| Project Name: TODNEM ADDITION       | EPC Application No.: Z-95-3 |

| PROJECT NAME LOTS 1-A-1 AND 2-A-1 TUDNEM ADDITION |                     |

**CITY OF ALBUQUERQUE  
PLANNING DEPARTMENT  
Development Review Board  
June 4, 2003 Comments**

**Subject: Todnem Addition**

PLAT OF
 LOTS 1-A-1 AND 2-A-1
 TODNEM ADDITION
 ALBUQUERQUE, BERNALILLO COUNTY, NEW MEXICO

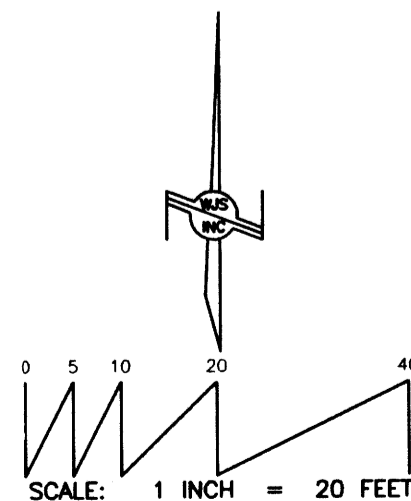
| No.                      | Comment  |
|--------------------------|--|
| <input type="checkbox"/> | A 4ft public roadway easement on Mildred is needed, also a 20 radius will suffice at the intersection. |

How will the owners of the home on Lot 2-A-1 maintain the north side of their house which is on the lot line?
